Paul Grinyer Associates Ltd

30th November 2020

STRUCTURAL INSPECTION OF GARAGE BUILDING (UNIT 3) – CONVERSION OF 23 MEAD LANE, BOGNOR REGIS TO THREE RESIDENTIAL DWELLINGS

Photo – Existing garage wall elevation.

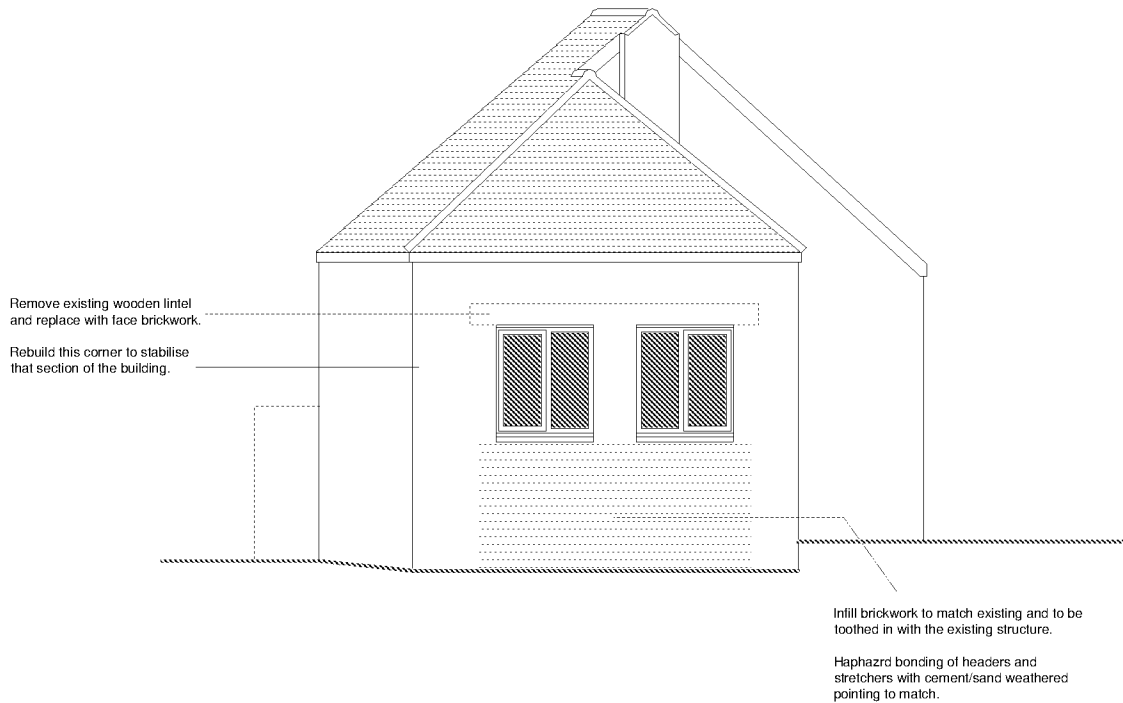
Having inspected the east and north elevations of the existing garage, we noted the brick quoin to the north east corner of the garage structure was out of plumb and bowed vertically over the height of the building.

The brick quoin was bonded to the flint masonry east external wall and poorly bonded to infill masonry on the north elevations, around the garage door frame.

The pre-existing movement to the existing brick quoin to the north east corner is such that it will not be possible to bond new brickwork to it whilst maintaining the correct lines and levels for the north elevation masonry. In addition, it is possible that trying to bond the new brickwork to the already deformed existing masonry, will destabilise the wall and corner of the building further.

In order to safeguard the longer term stability of the garage structure and to extend its longevity for the foreseeable future we strongly recommend that the existing brick quoin to the north east corner of the garage structure is rebuilt in its entirety, bonding back to the existing flint east wall and re-using existing or similar reclaimed bricks where possible.
